CITY OF ALBUQUERQUE

PLANNING DEPARTMENT – Development Review Services

June 3, 2014

**RE: Pasadena Office/Warehouse
Conceptual Grading and Drainage Plan
Engineer's Stamp Date (no stamp) (B18D019)**

Date:	No.	Revision:	Date:	Job No.
5/8/14				2052
Drawn By: BJB				CG-101
Ckd By: FCA				SH. OF

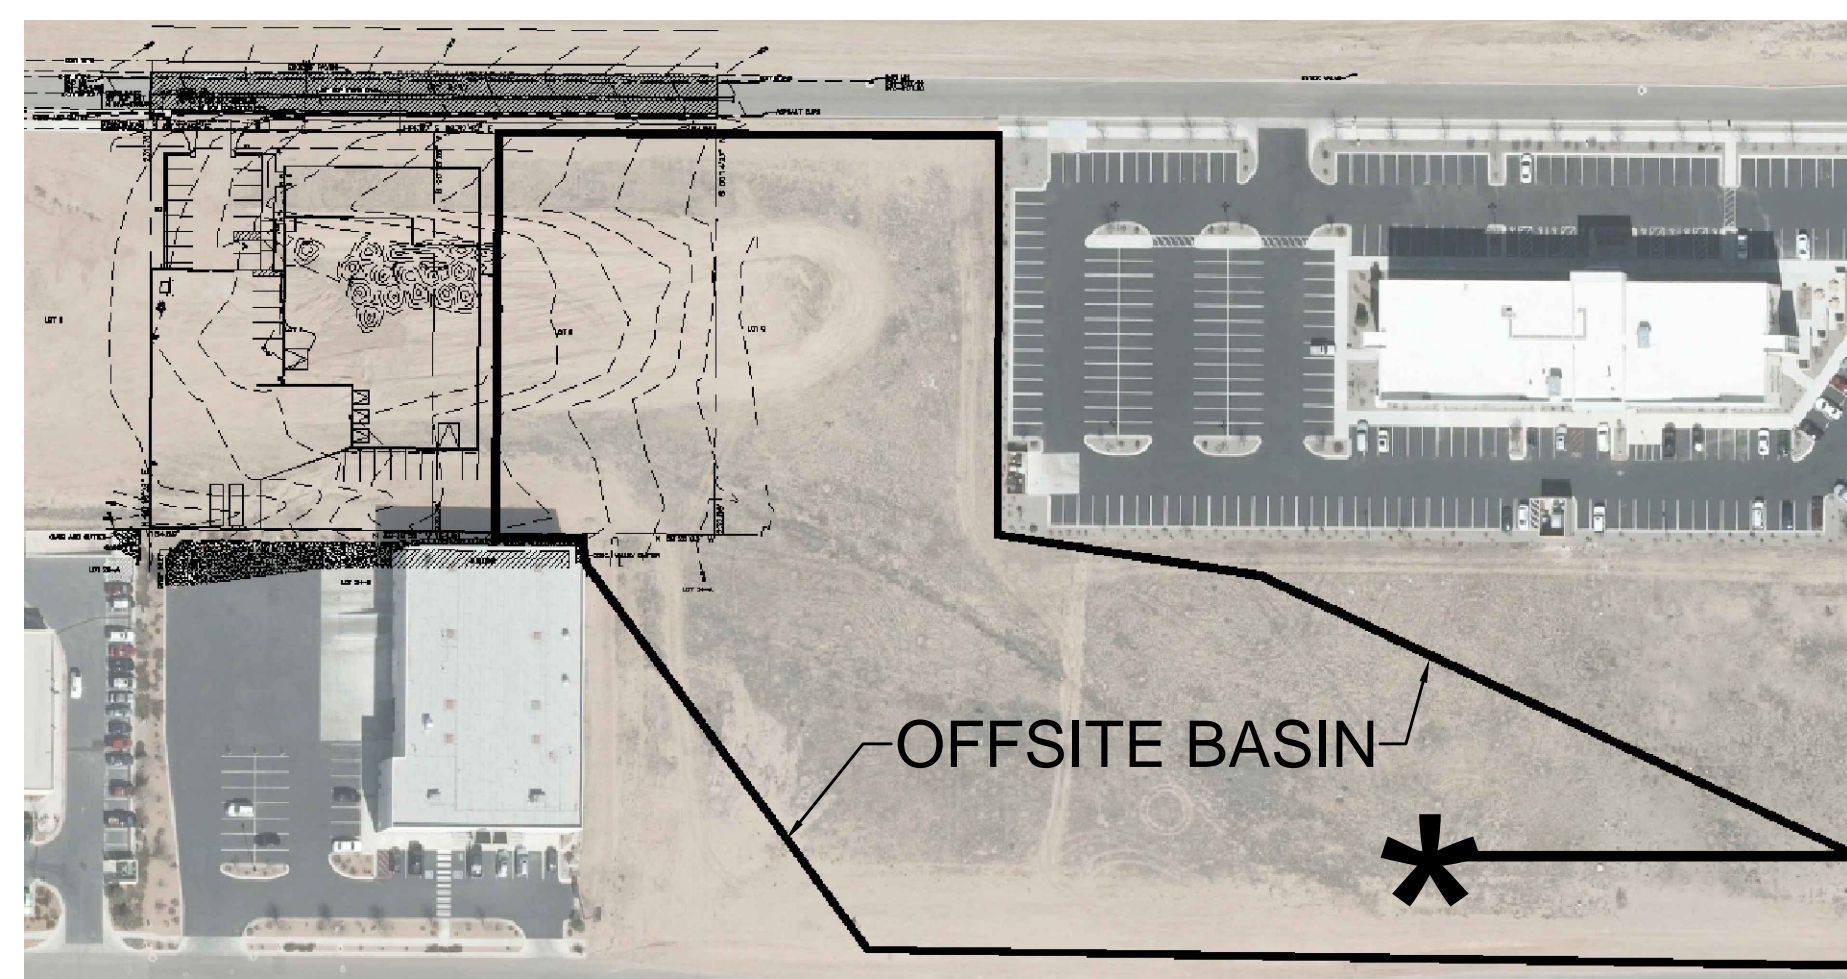
1. In PROJECT DATA, change the vicinity map from C-17 to B-18.
2. The As-Builts of the existing Storm Drain (CPN # 630982) show a 36" Storm Drain in front of Lot 5A, and the report in Weiss Engineering (Drainage File B18D006) indicates that 36" Storm Drains were intended for this street, and both indicate 60 cfs

3. Construction drawings (CPN# 546991 – in B18D006) show 48" SD pipe in San Mateo connection to SD pipe in Pasadena with an HGL close to surface. The same is shown in As-Builts (CPN#630981) Sht 10/15. Therefore, downstream pipe cannot accommodate additional flows for which it was designed.

4. In Drainage Report for Citicorp Site by Bohannon-Huston (1996) developed conditions for this area are limited to 4.1 cfs/acre whereas this Plan shows 4.7 cfs/acre. Flows should be reduced to the design flows.

5. The offsite basin does not account for flows west of I-25 and south of development on Lot 10A
